CITY OF ALBUQUERQUE

RE: UNM Starbucks and Freddie's
Grading and Drainage Plan ^{MA}
Engineer's Stamp Date 1-27-2017 (File: K16D075)

Based upon the information provided in your submittal received 1-30-2017, the above referenced Grading and Drainage Plan cannot be approved for building permit until the following comments are addressed:

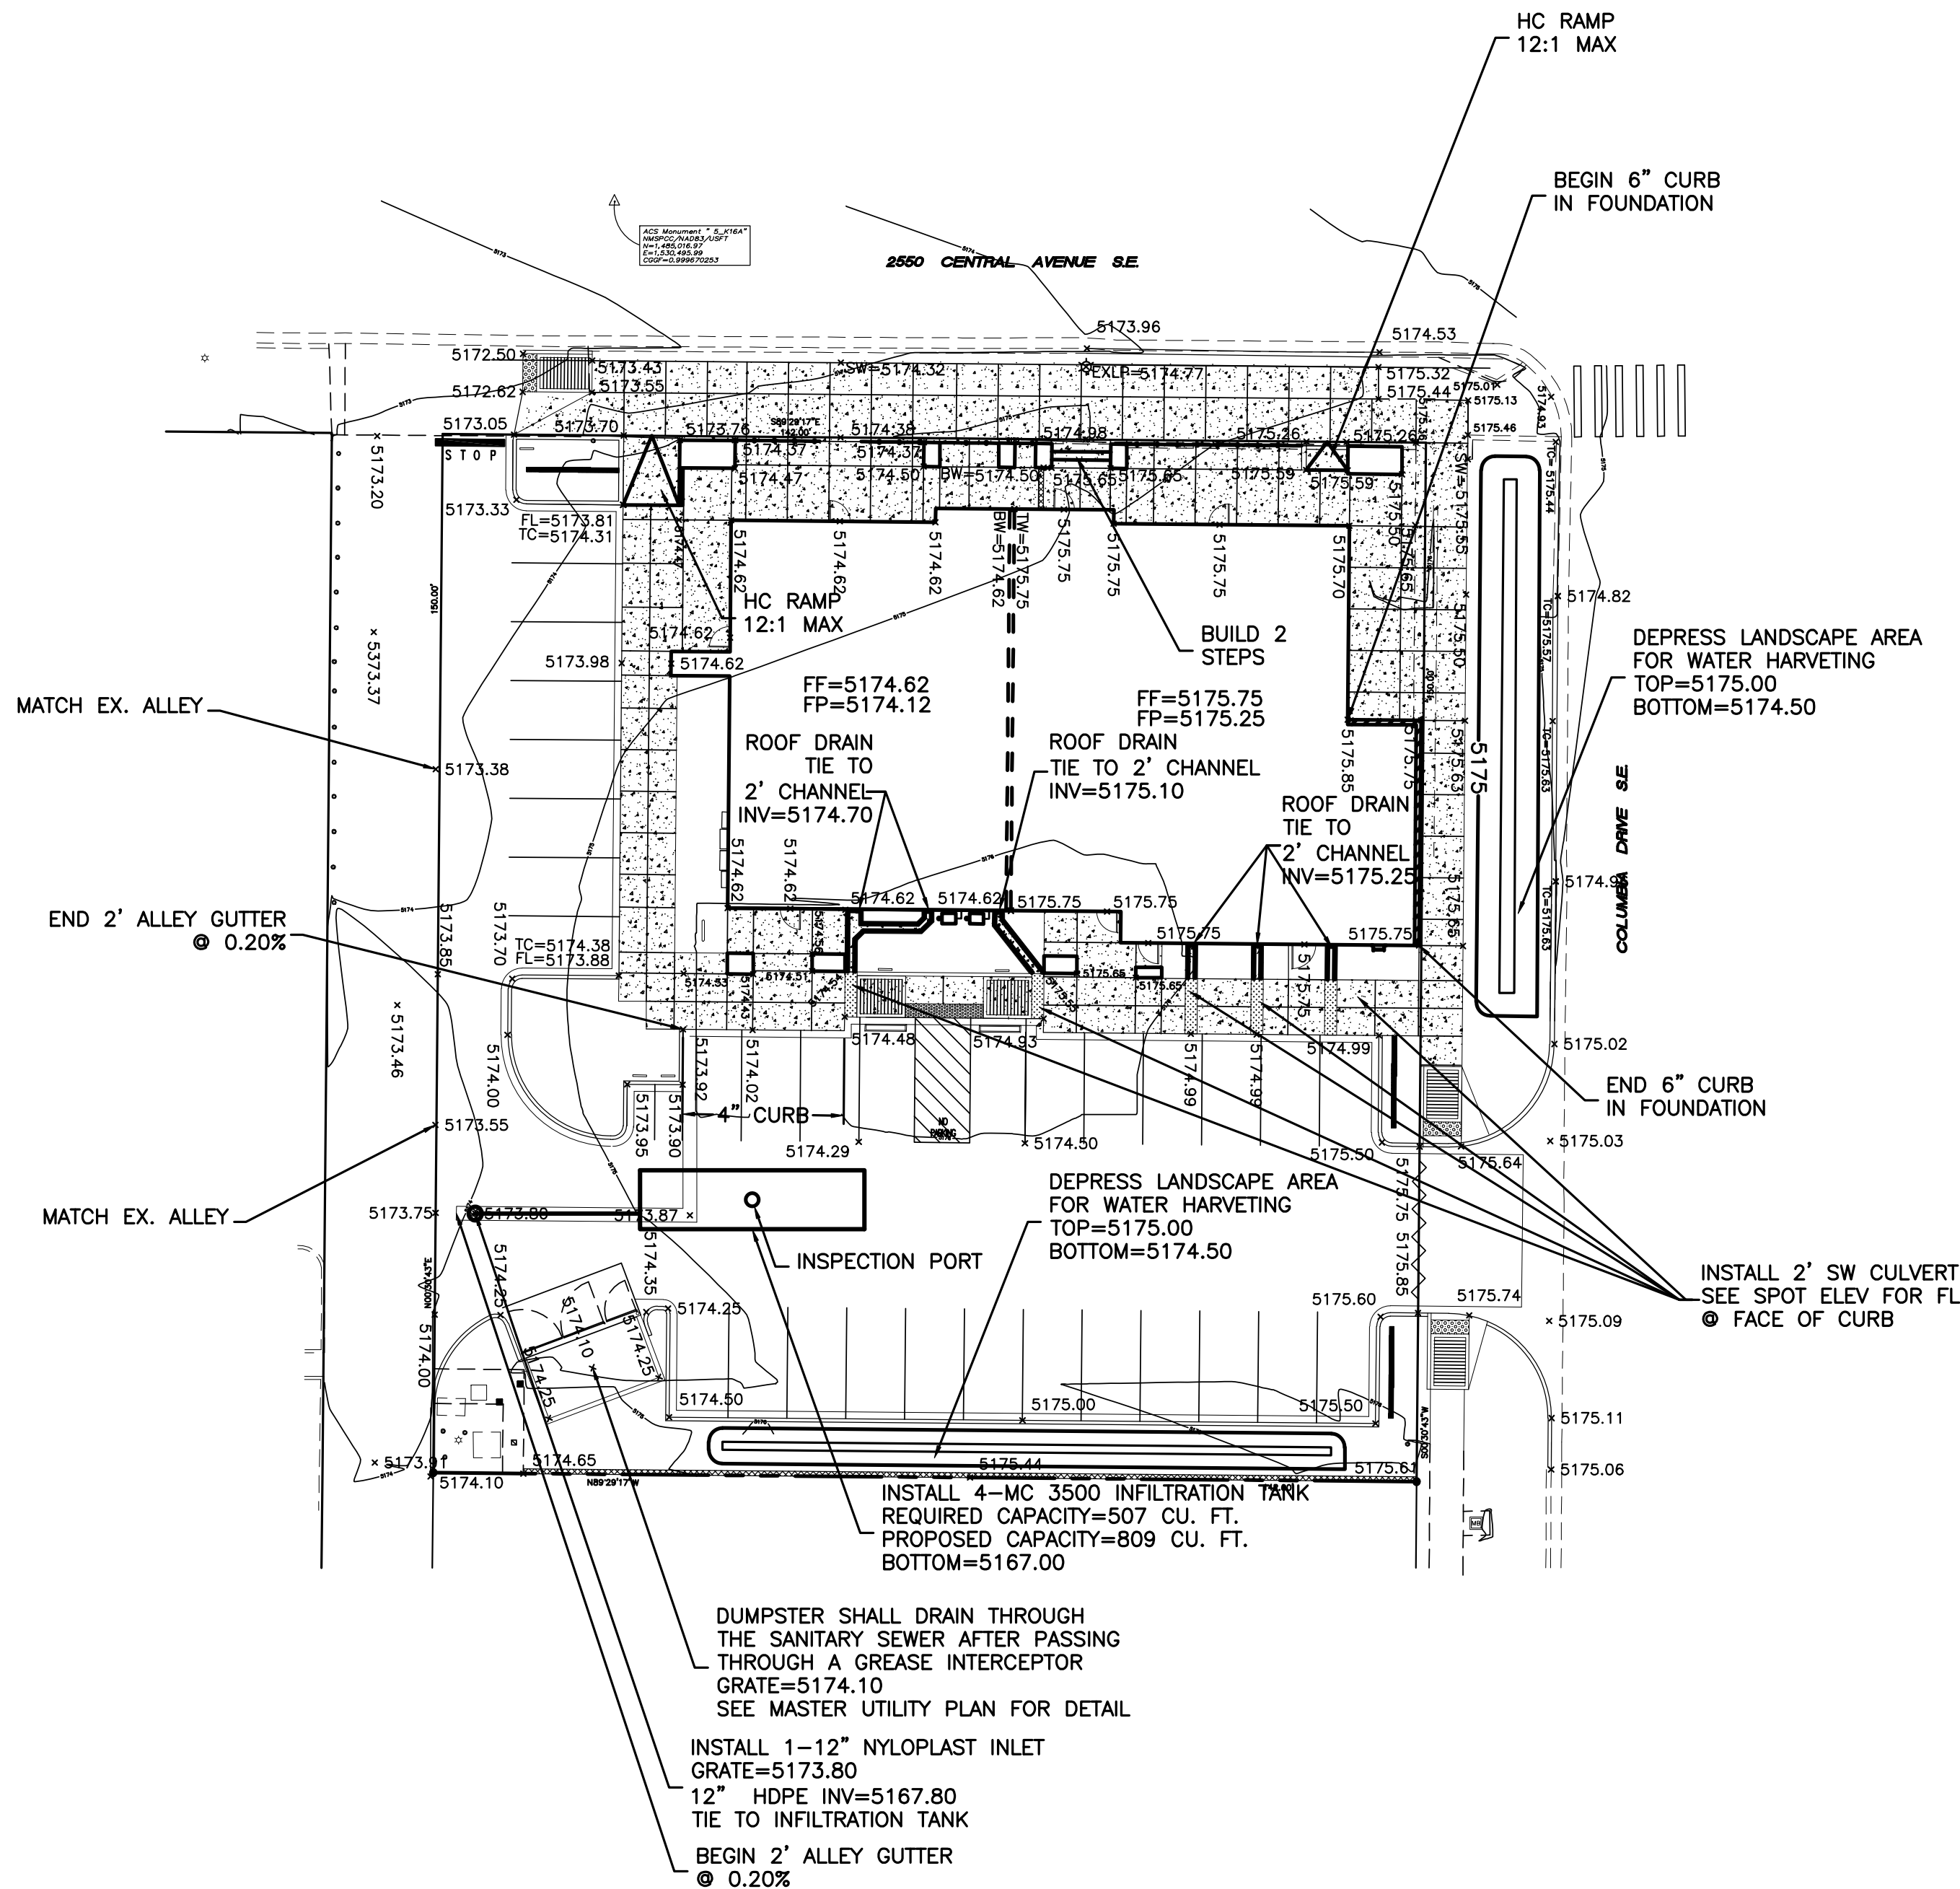
1. Provide build note and grade elevation for the dumpster.
2. Provide narrative for offsite flow.
